**To: Dom Cox: N6/2013/1938/MA Council Office Extension**  
**Member, Development Management Committee**

I wish to register my objection to the above planning application on the following grounds:

Title Proposed Materials

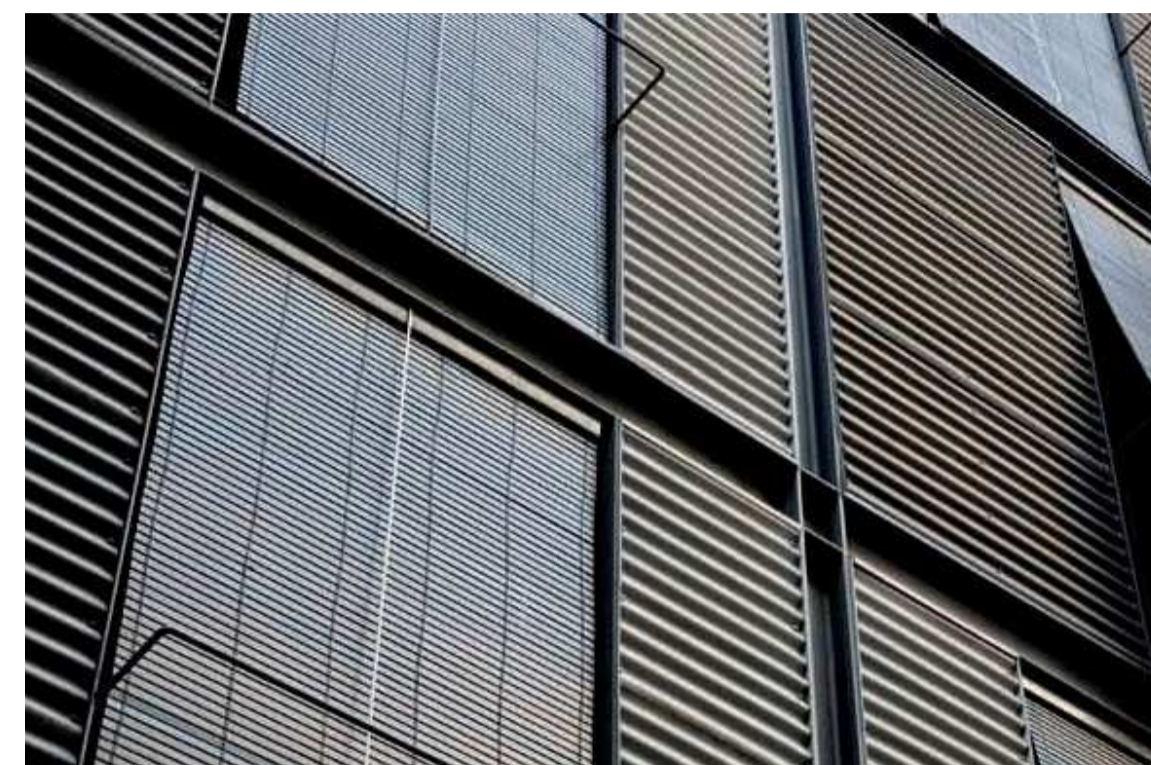
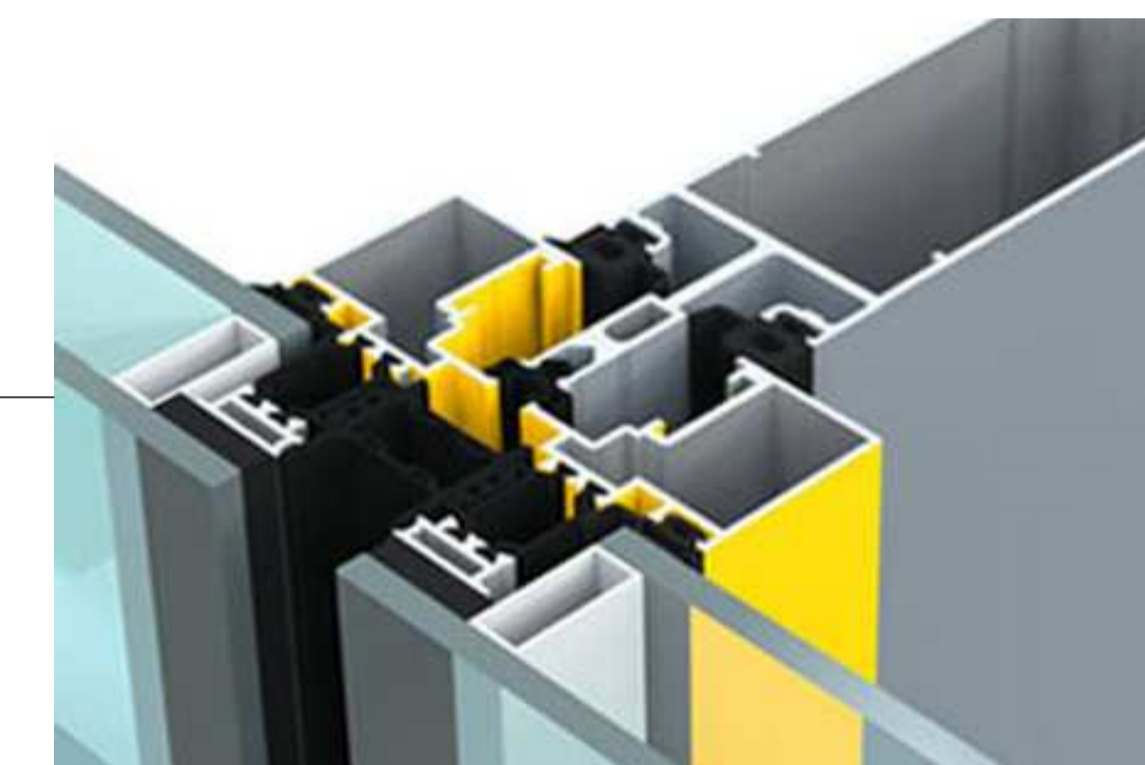
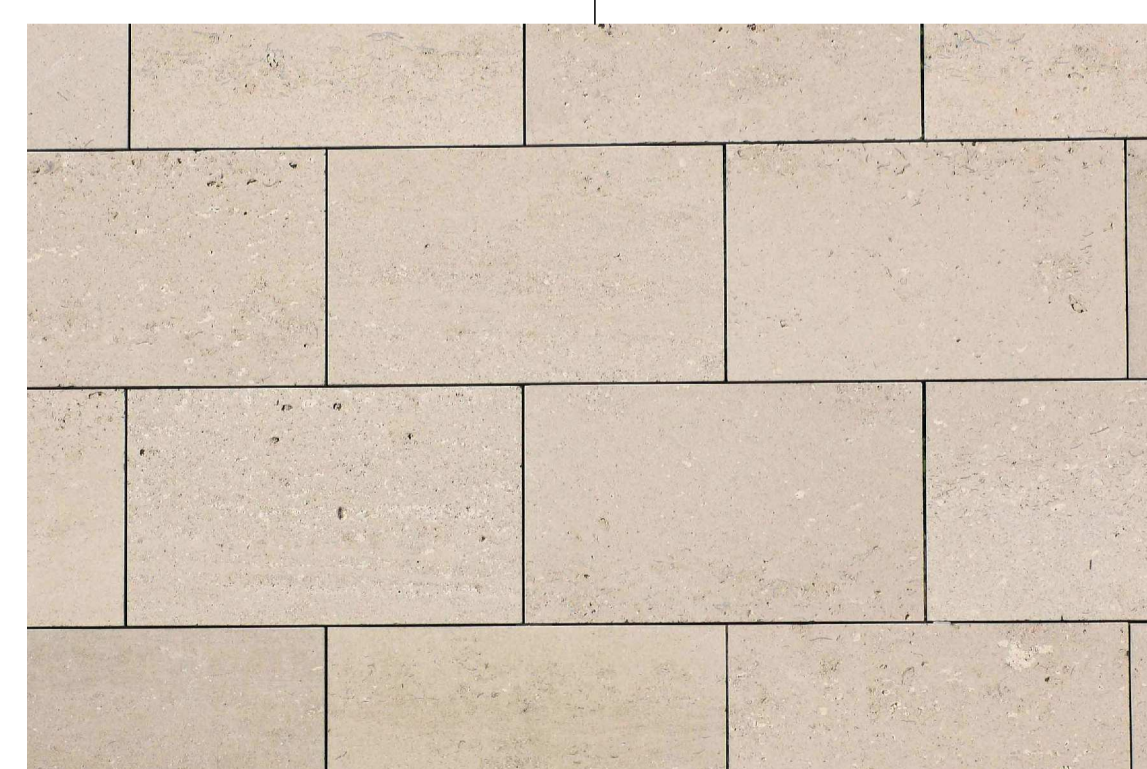
2. The proposed design, its materials and proportions, are both inappropriate for such an extension which is a rear entrance to an existing building.
3. The internal layout appears to fail Building and other regulations for office space and sustainability requirements. The proposed design of the Council chamber restricts its use for public meetings.
